## Application for a Non-Material Amendment Following a Grant of Planning Permission

Erection of two storey rear extension, and conversion of roof space into habitable use to include a rear dormer and 2 no. side facing rooflights.  
Rendering of external walls.

16147/APP/2024/2912

Alteration to fenestration - 2 no. windows in the front elevation.

Proposed Front Elevation

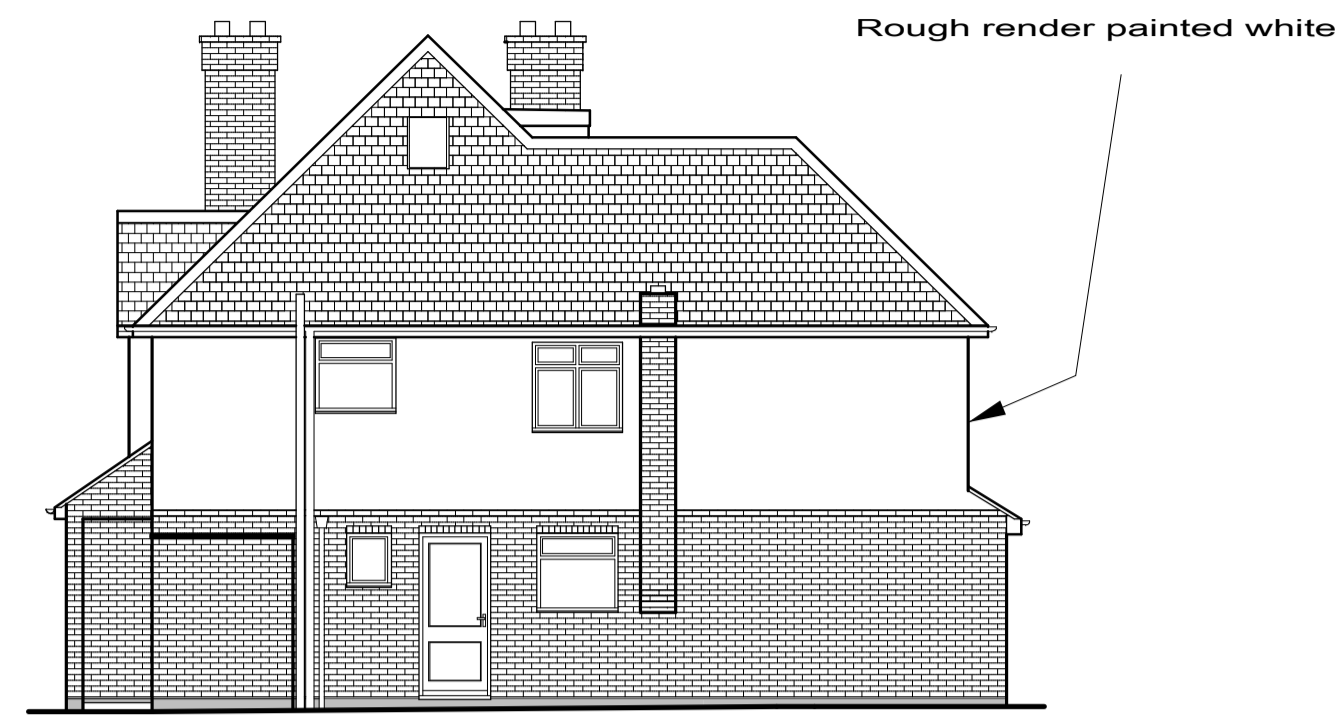
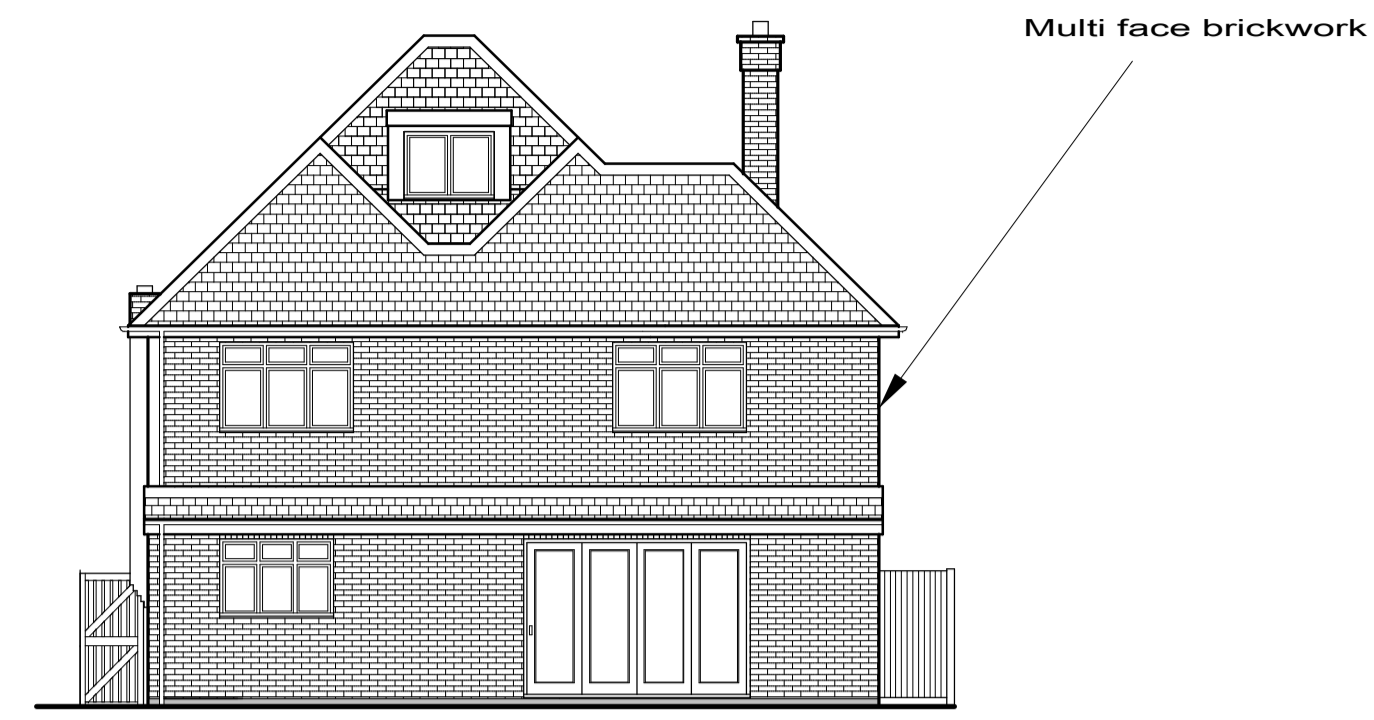
To improve the appearance of the front elevation and the outlook of the internal habitable space.

4057/2G
